10 October 2025
Ref 24526

SSD-77825469
2-16 POCKLEY AVENUE, ROSEVILLE
TRAFFIC AND PARKING MATTERS

Department of Planning, Housing and Infrastructure Response

Ku-ring-gai Council Response

04.03 Building Basement 03 Floor Plan

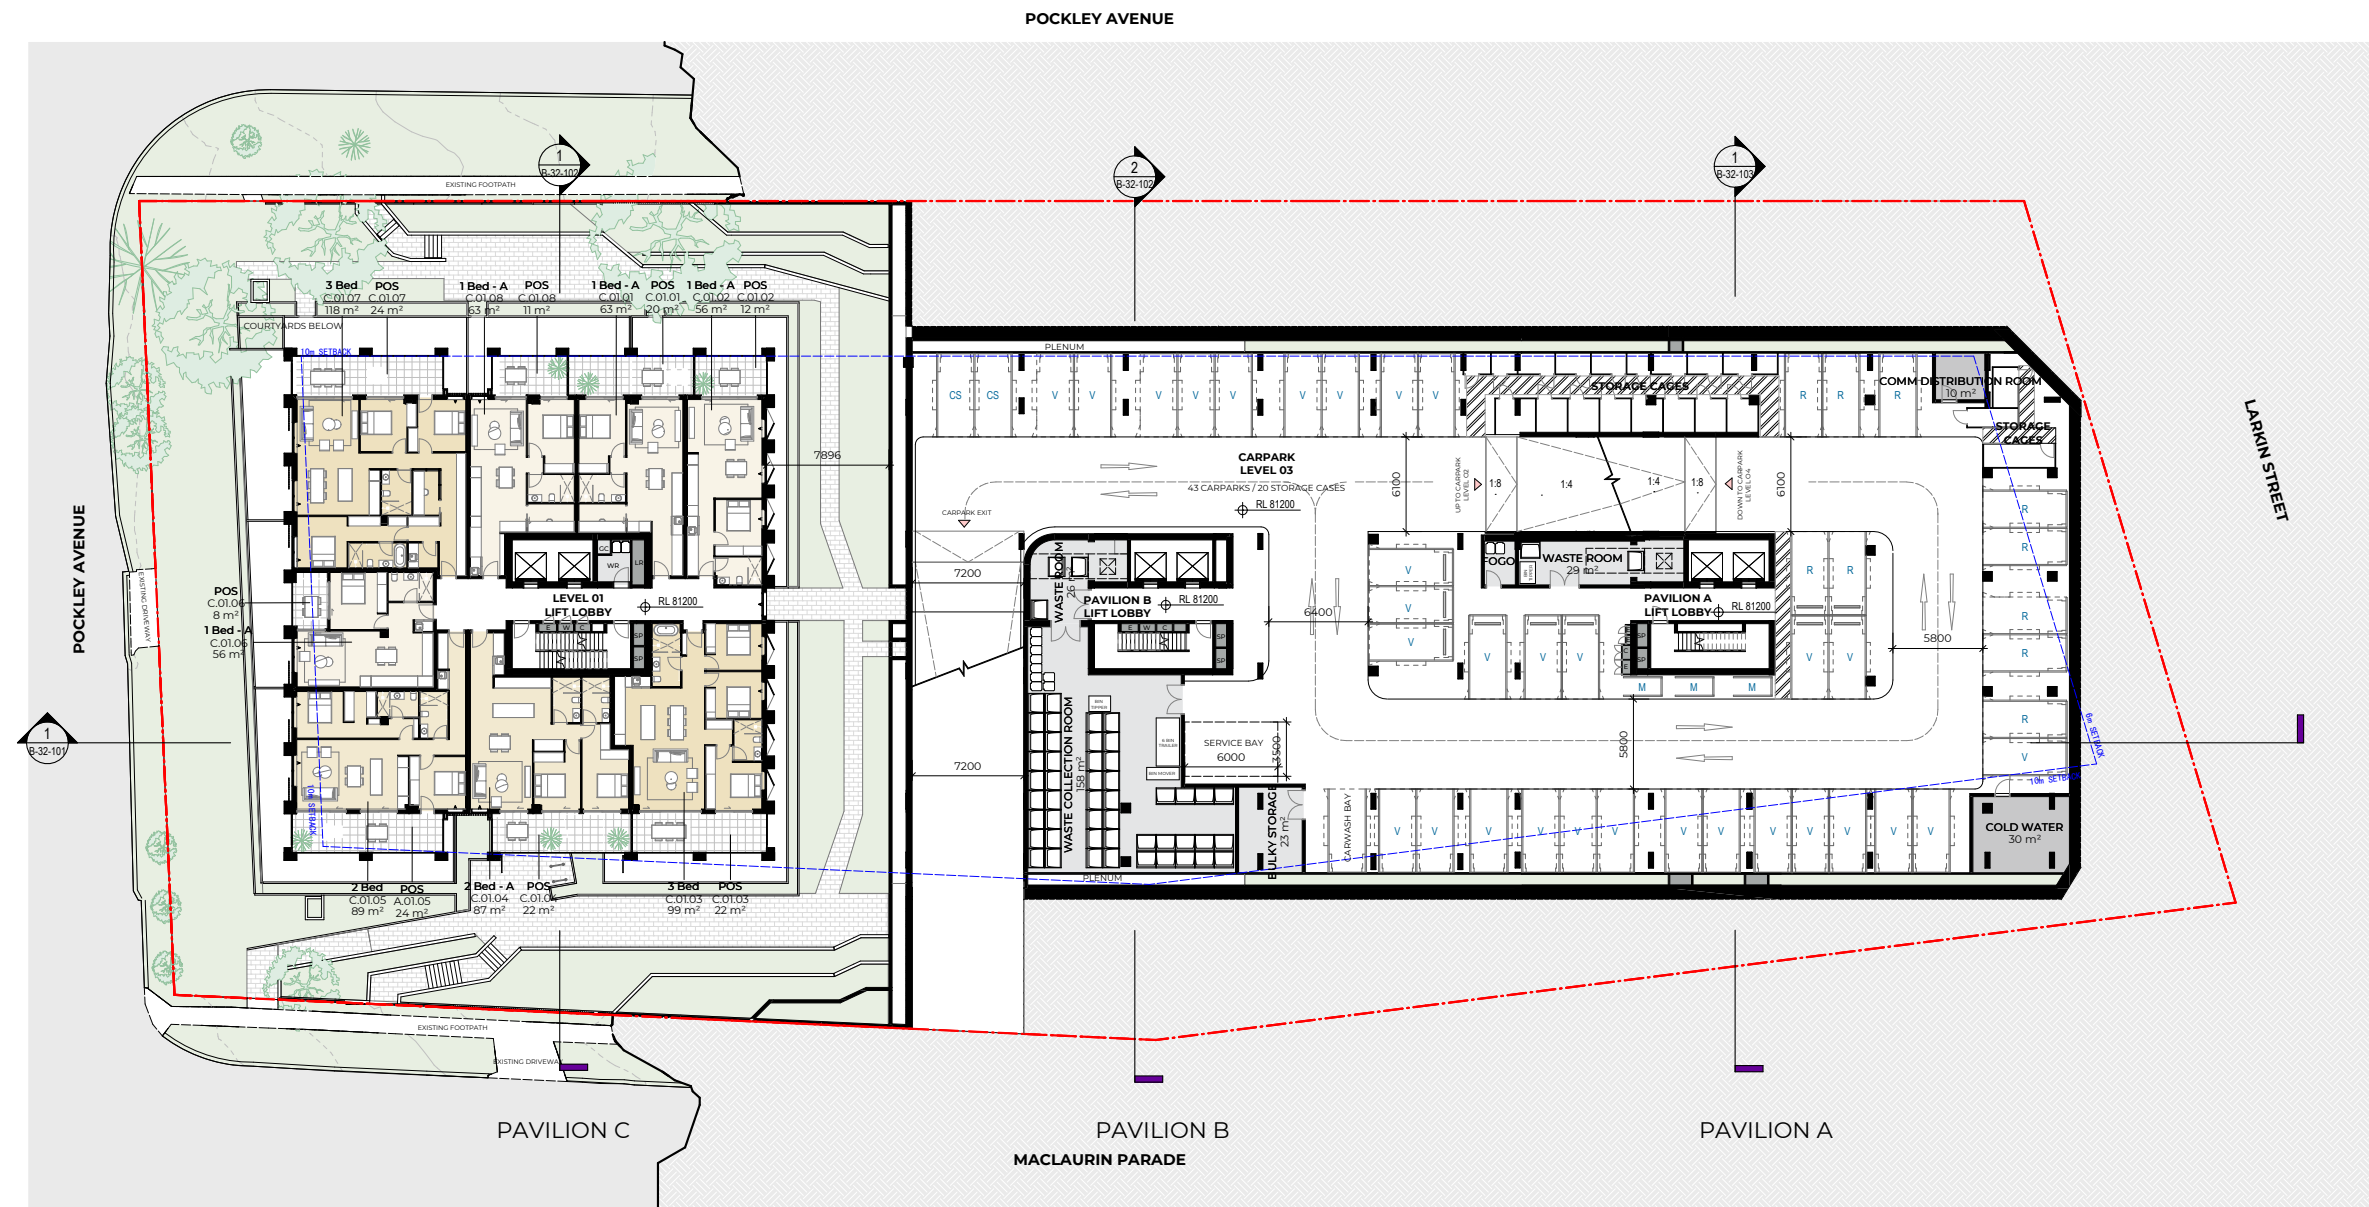
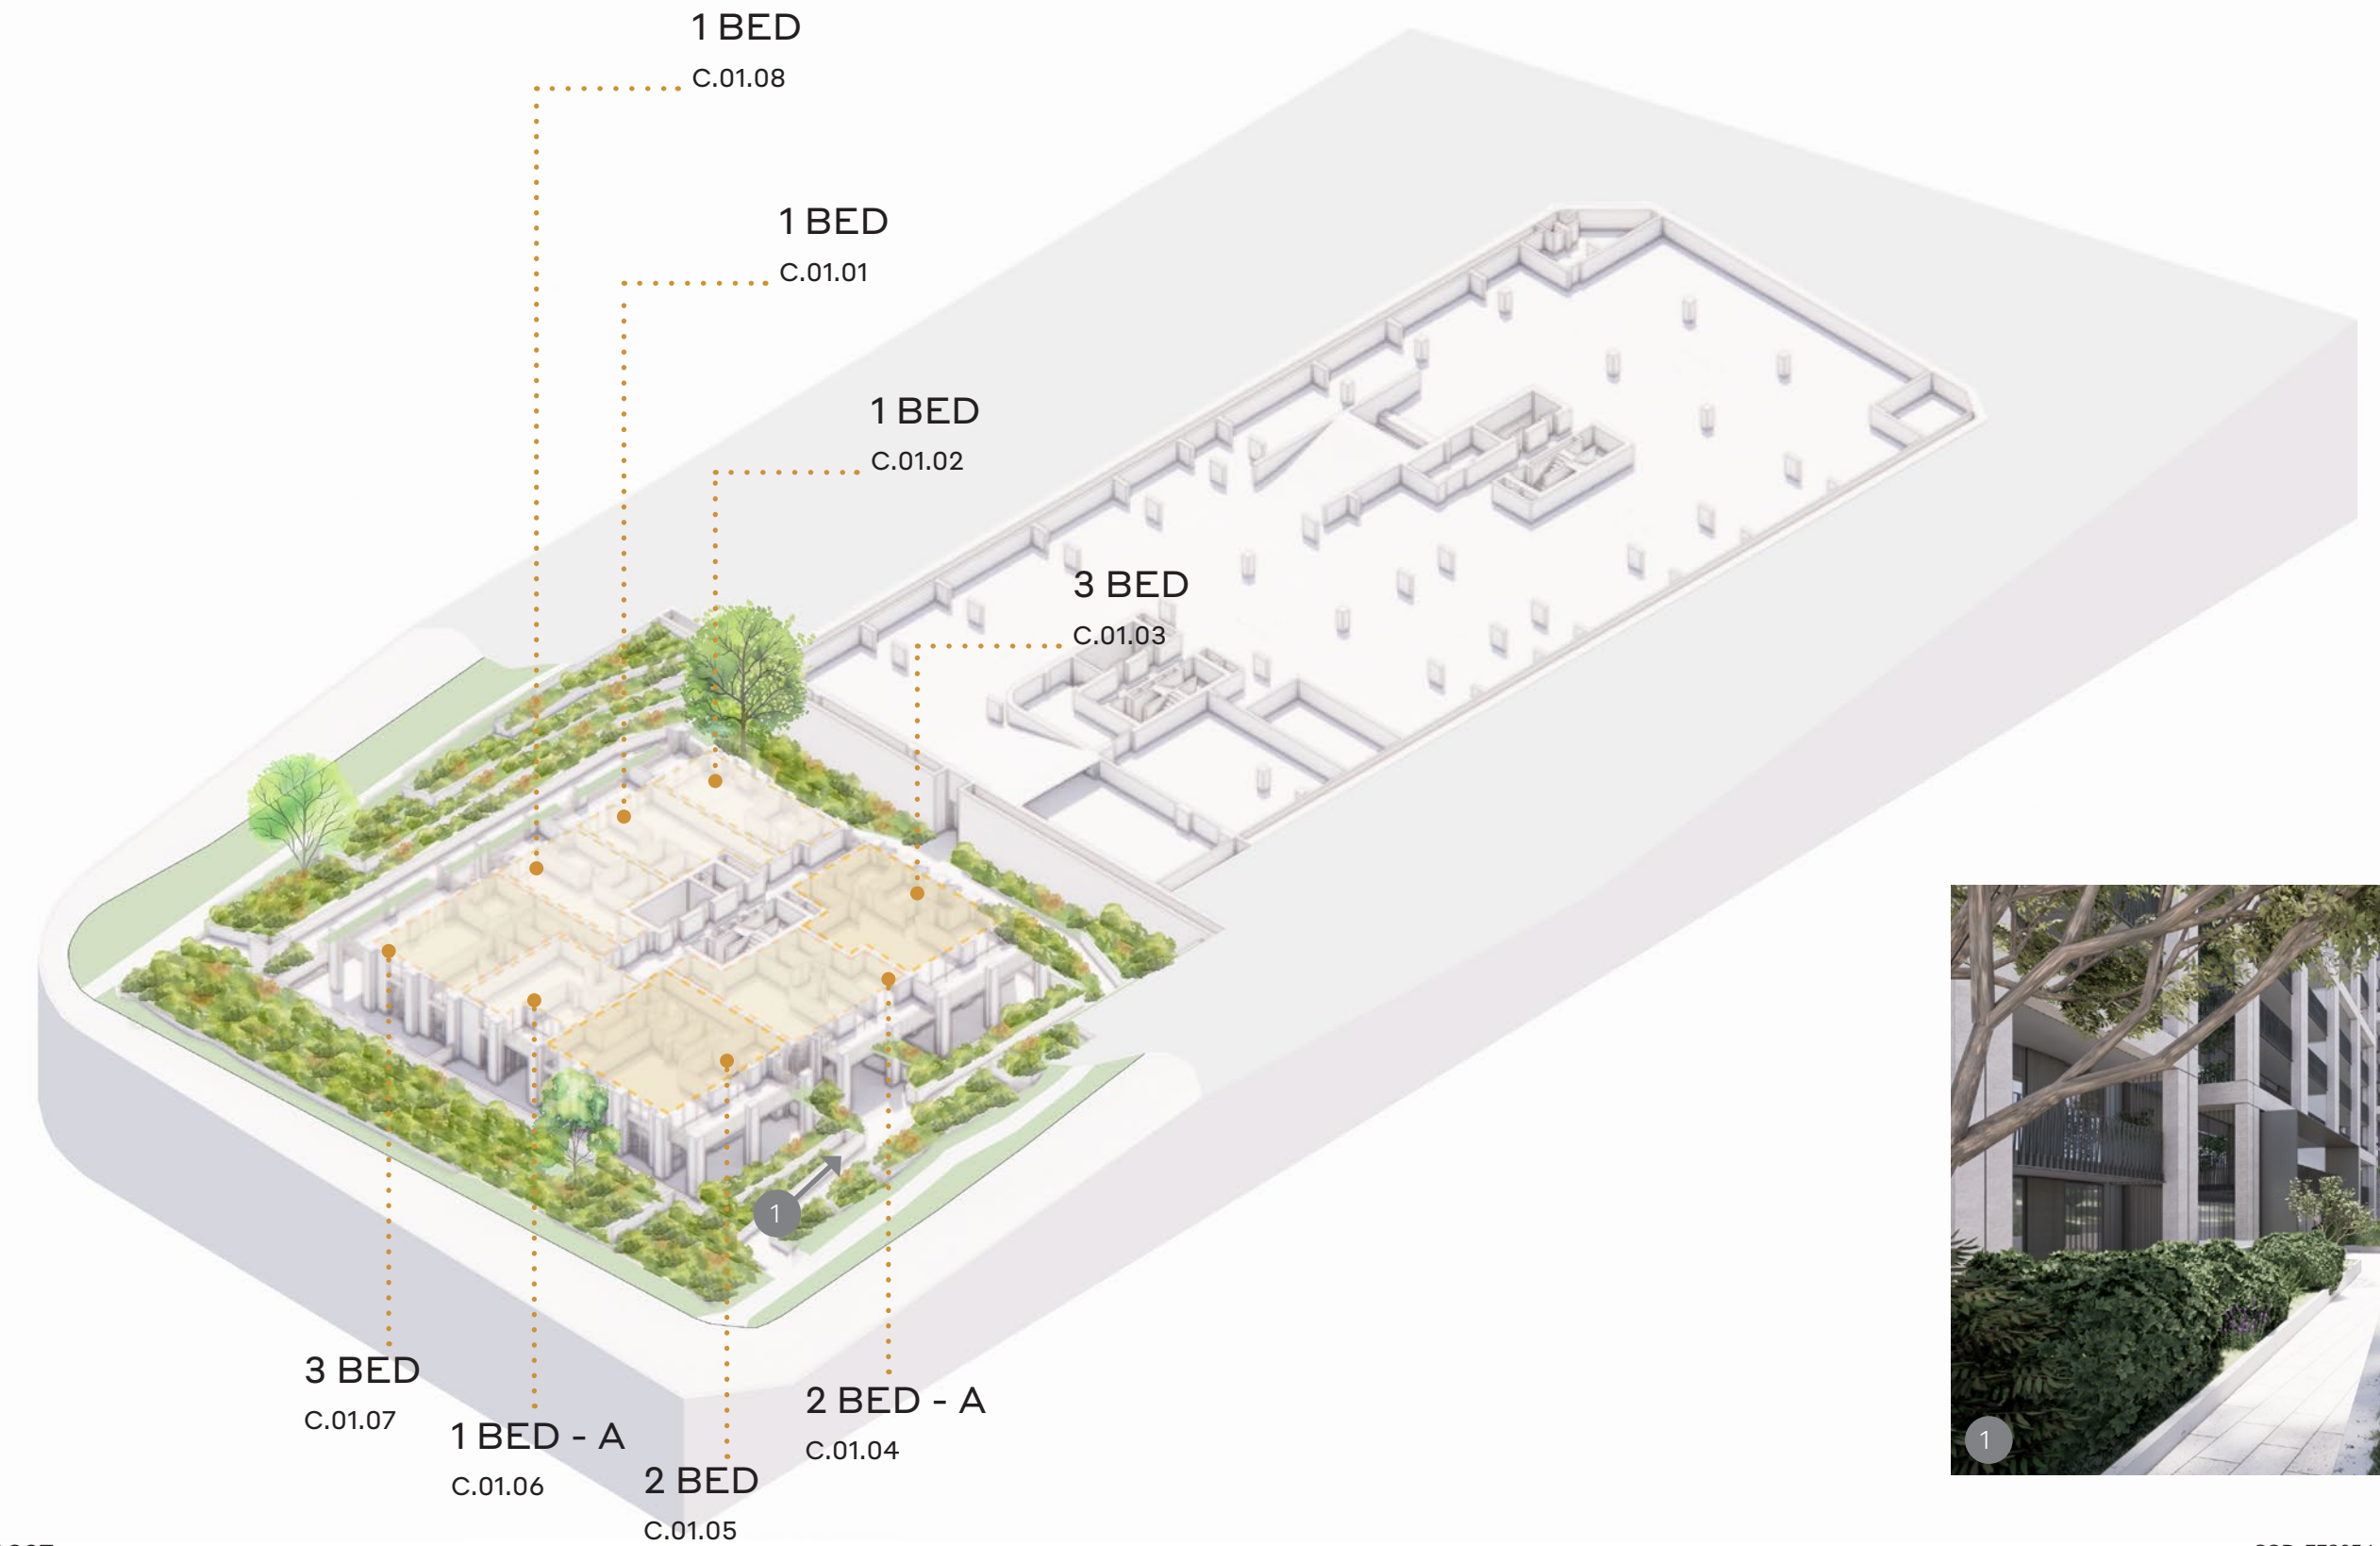
7. *At least 5 car parking spaces on Basement 03 level are to be reserved for car share operation, with no charge to the car share operator to use the space/s.*

The Ku-ring-gai DCP requires *1 car share space per 90 dwellings*. Application of this requirement to the 178 dwellings equates to a requirement of 2 car share spaces.

The proposed provision of 2 car share spaces is therefore considered acceptable. These spaces will be reserved for car share operation, with no charge to the car share operator to use the spaces.
